# CITY OF PORTLAND

## BUILDING PERMIT

Job ID: 2011-12-2859-ALTR

has permission to Replace four (4) existing bedroom egress windows per previous permit # 040110.  
provided that the person or persons, firm or corporation accepting this permit shall comply with all of the provisions of the Statues of Maine and of the Ordinances of the City of Portland regulating the construction, maintenance and use of the buildings and structures, and of the application on file in the department.

214 Basement
Saint John St.
Portland, ME 04102

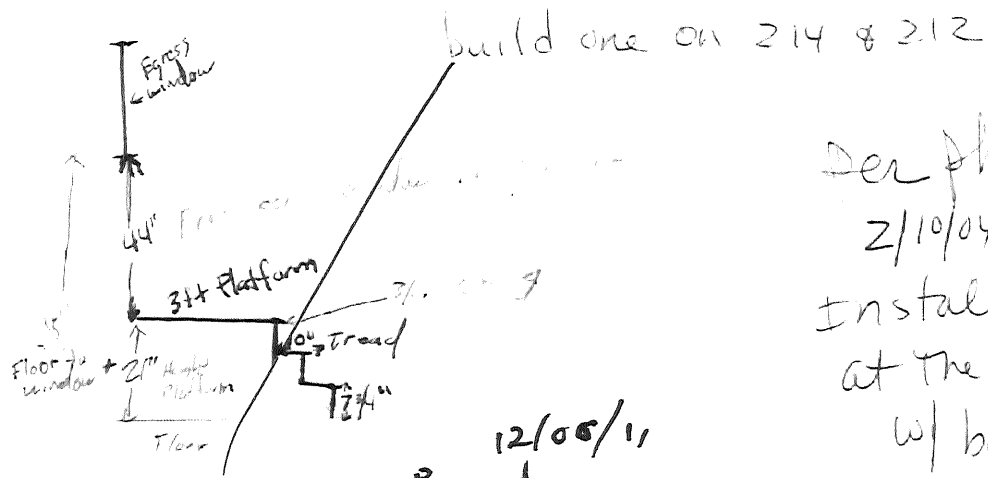
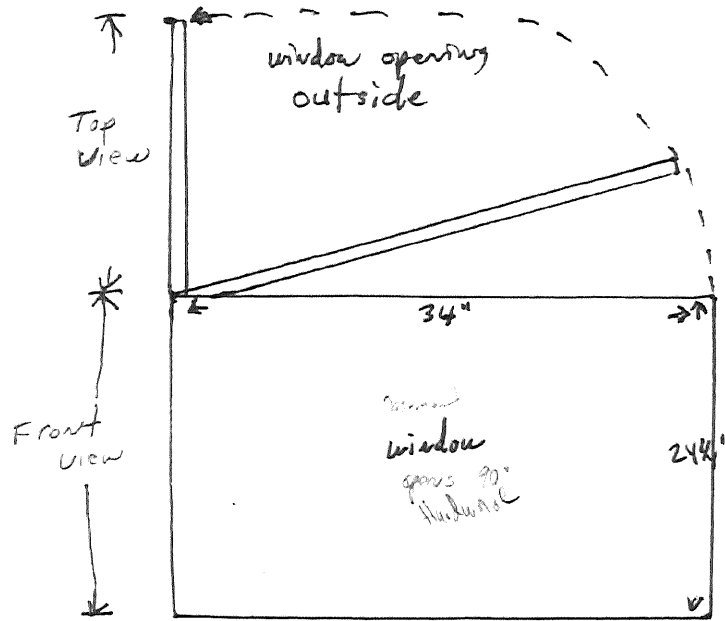
7. **Note: Header and Girder spans for each window must comply with Table R502.5(1) if new framing is required. A Close-In inspection will verify if modifications are required. Met with Owner he will create a window well for both basement casement windows; and remove the proposed egress window steps in the basement. See attachment for for code specifications.**

Den phone call to Timly  
 2/10/09 - He agrees to  
 install a 36" high Guard  
 at the platform & stairs  
 w/ balusters < 4" space
